Application No: EP/47/21/HH
Site Address: West House South Strand East Preston BN16 1PN
Description of works: Erection of second floor addition, part single storey side, part two storey front, side and rear extensions and alterations to fenestration/openings

Re: Planning Application - EP/47/21/HH

The management board of the Angmering on Sea Estate Residents' Association wishes this letter to be accepted as an OBJECTION to this proposal.

PR RF PLAN

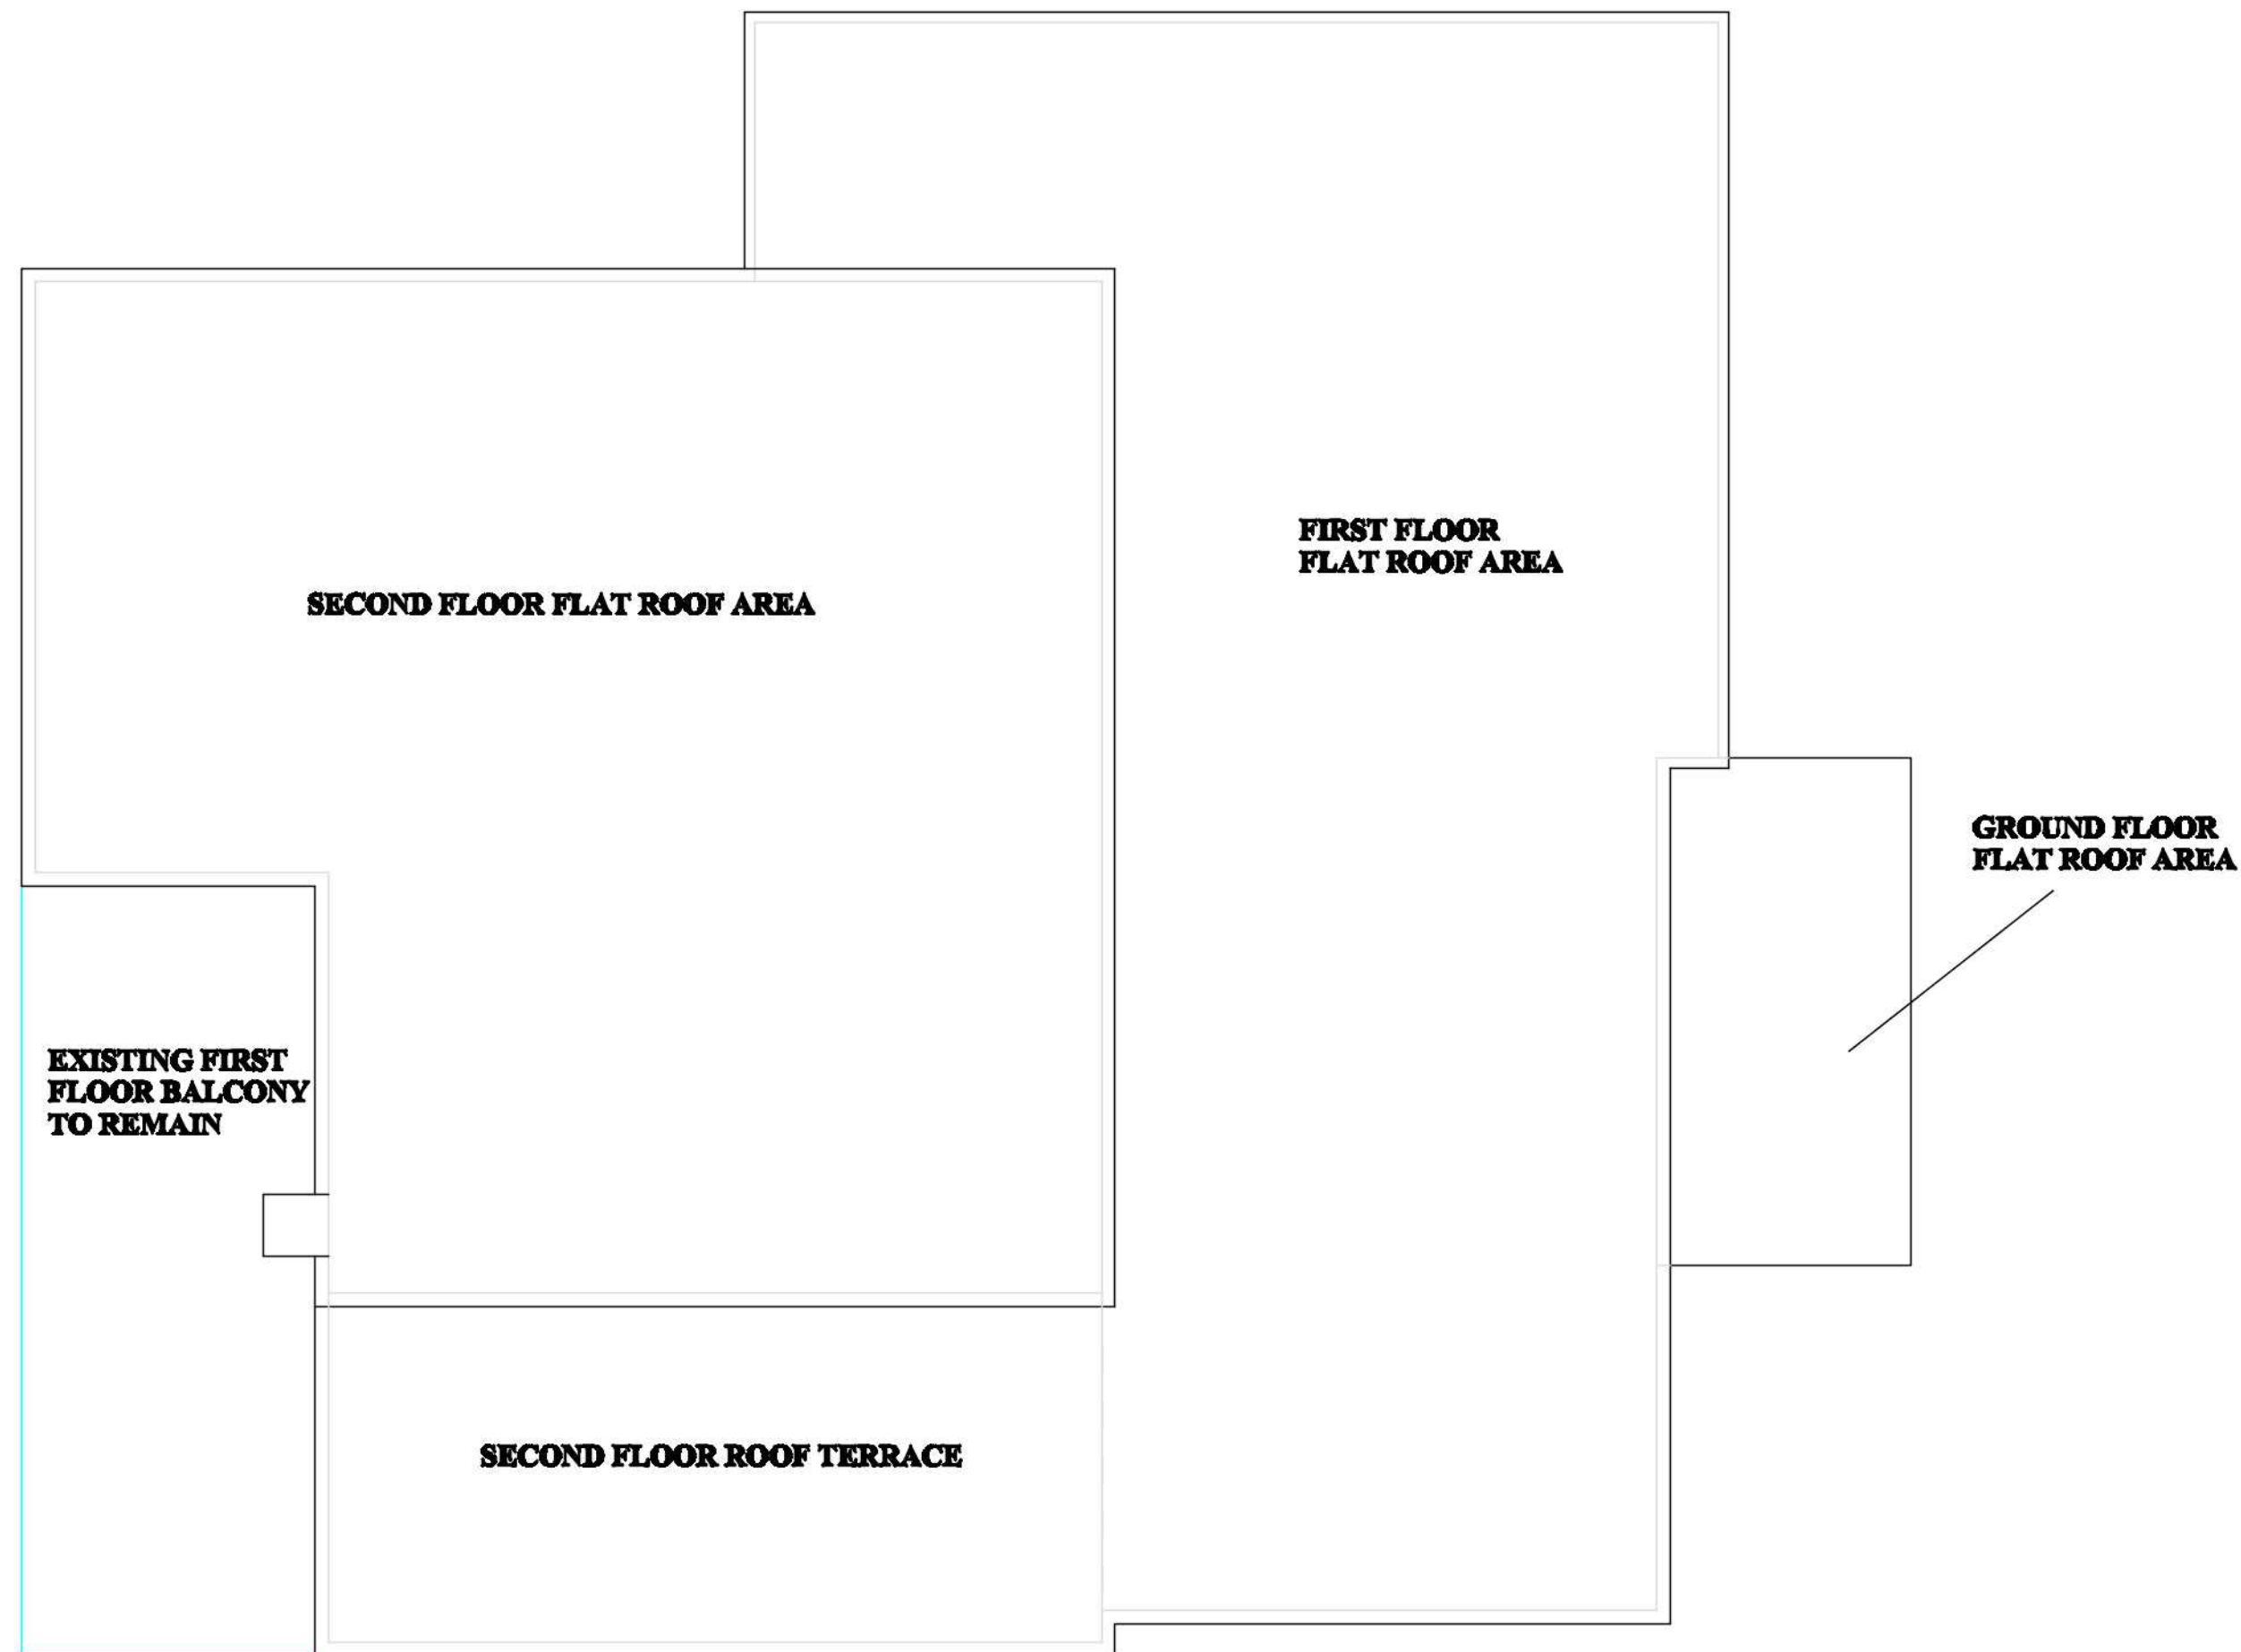
West House, South Strand, is in an area where the street scene is one of character and uniformity with the dwellings being of a traditional pitched roof design. The proposed alterations to this roof will significantly alter the appearance of the property and will fail to respect the overall character of the street scene through its design, scale, and mass. Further, the height of the proposed development at 8315mm will be taller than any other building in the immediate area. The 'blockhouse' design will result in a dwelling which, in the context of the plot, will be overdeveloped and totally out of keeping with its surroundings. The proposed development will have five windows in its eastern elevation which will overlook the adjoining property and its garden. The proposed roof terrace will also be capable of overlooking the amenity space of the neighbouring houses.
